SITE DEVELOPMENT PLANS FOR  
SLIM CHICKEN'S  
FALCON MARKETPLACE LOT 9  
A PARCEL OF LAND LOCATED IN A PORTION OF THE SOUTHEAST QUARTER OF SECTION 1,  
TOWNSHIP 13 SOUTH, RANGE 65 WEST OF THE SIXTH PRINCIPAL MERIDIAN,  
COUNTY OF EL PASO, STATE OF COLORADO  
PCD FILE #PPR-21-026

SITE DEVELOPMENT PLANS FOR  
**SLIM CHICKEN'S  
FALCON MARKETPLACE LOT 9**

DATE	DESCRIPTION	COVER SHEET
2021.06.15	1ST SDP SUBMITTAL	C0.00

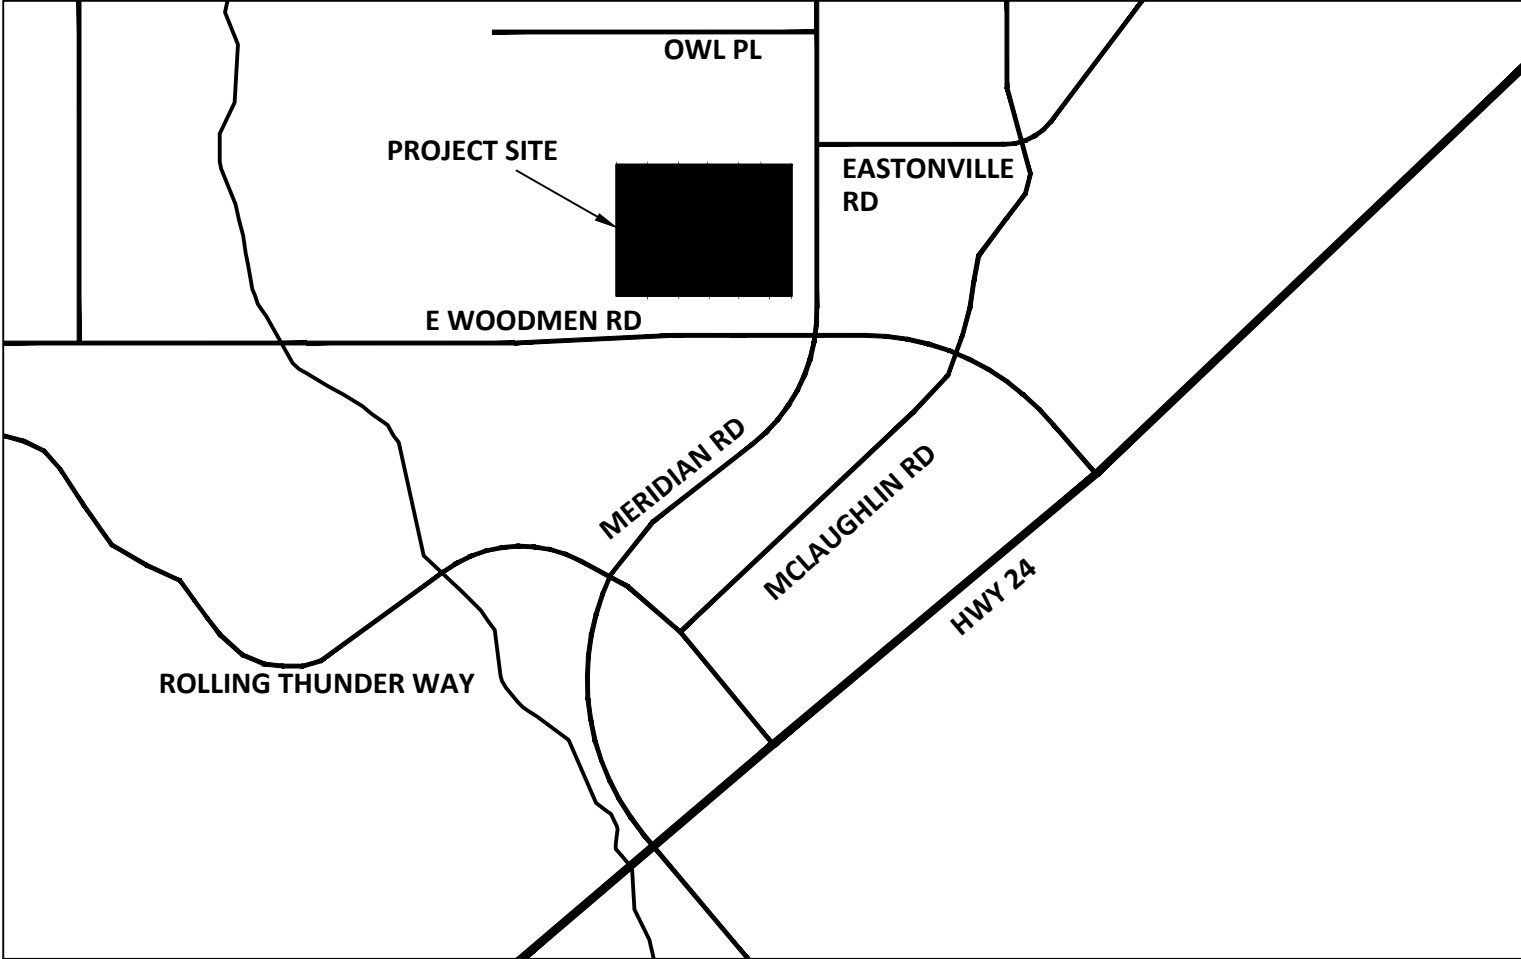
Correct legal description as follows or remove since redundant information:

4,023 sq. ft. would result in 40 parking spaces required per LDC Table 6-2 which requires 1 space per 100 sq. ft fast food drive thru use.

Please ensure proper counting for parking spaces. I counted 39 spaces, including the ADA spaces. ADA spaces can count toward total number. You need 40 spaces to meet the LDC requirements.

Move all of these info the data table and correct the discrepancy between owners - in the table it lists BWR Investors and in the contacts it lists WRG Investors.

remove County  
Engineer signature  
line
